REQUEST

Current Zoning: I-2 (general industrial)
Proposed Zoning: MUDD(CD) (mixed use development district, conditional)

The petition proposes development of a vacant site for up to 275 multi-family residential dwelling units and minimum of 3,000 square feet and up to 8,000 square feet of non-residential space or an option for up to 85 single-family attached townhome units.

STAFF RECOMMENDATION

# RZ-3.0

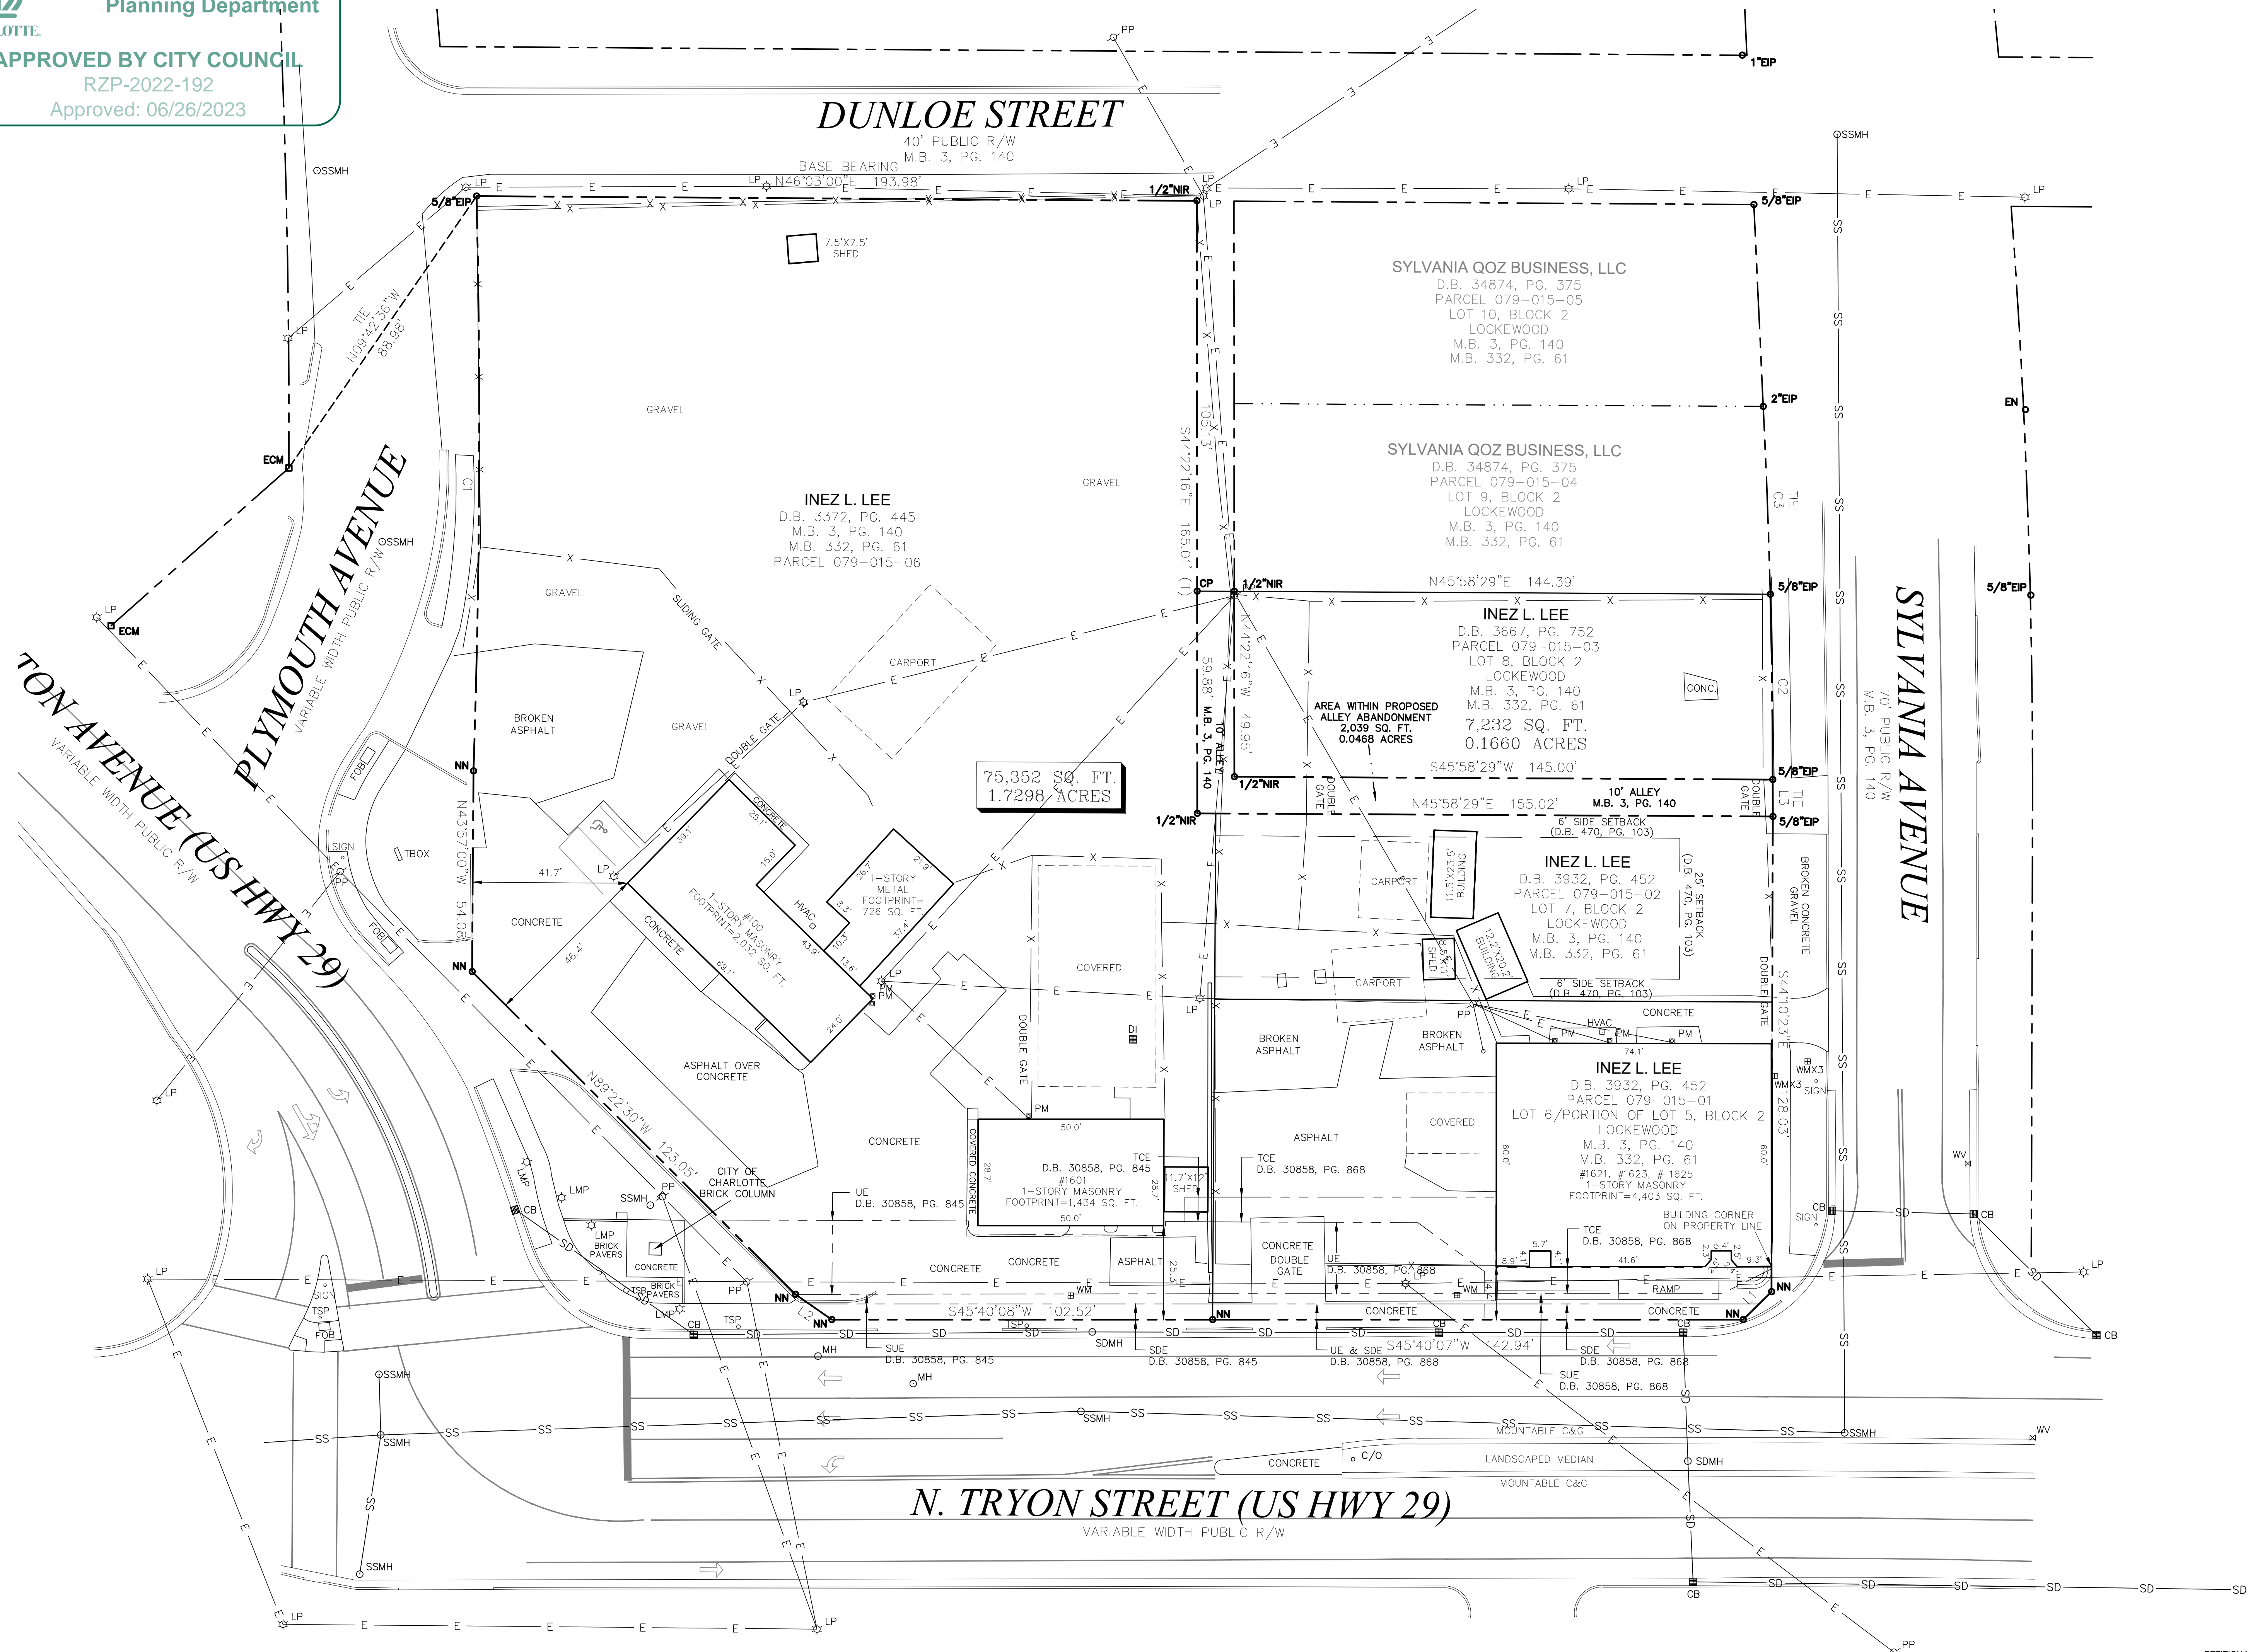
1. Dalton Street: location of future curb and gutter to be moved 35-feet from roadway centerline to accommodate the Charlotte Streets Map with a roadway section of 4+ Avenue and Bike Lanes. Add conditional note that the curb line location is to be finalized during permitting in coordination with CDOT to accommodate Charlotte Streets Map.
2. Add a conditional note specifying "All transportation improvements will be approved and constructed before the site's first building certificate of occupancy is issued. The petitioner may phase transportation improvements if said improvements and phasing are explicitly described in site plan notes."
